Supporting Statement.

Variation of Conditions on planning reference number 2020/91838.

Erection of raised terrace at

90 Lingards Road, Slaithwaite HD7 5HY.

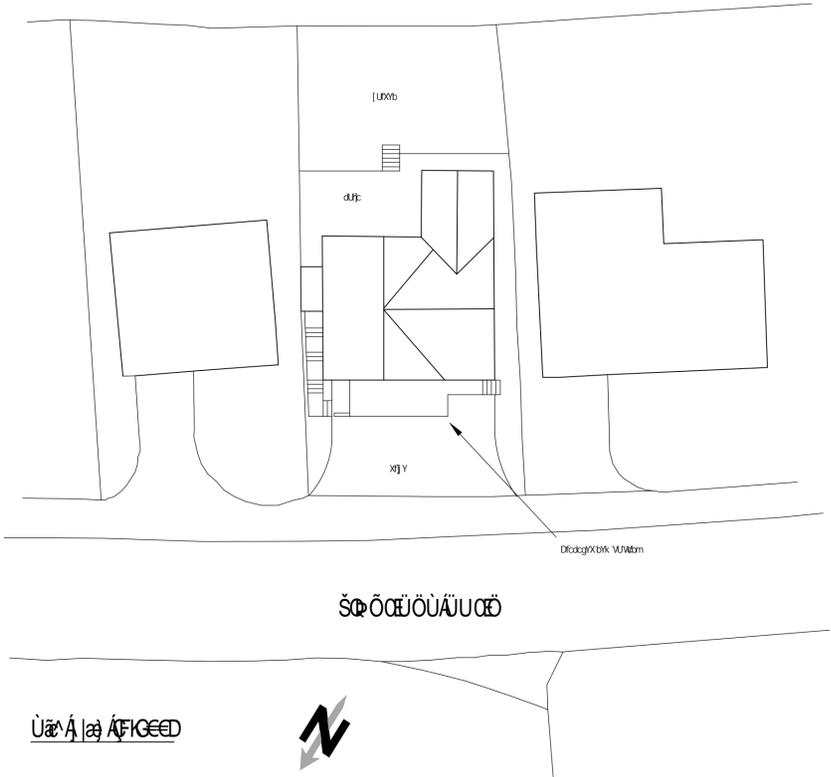
It was proposed to remove and relocate the retaining wall to the south western boundary but this is now going to remain in it's current location so the drawing has been updated to reflect this.

The drawing has also been updated to reflect the proposed finish to the steel frame, as mentioned above.
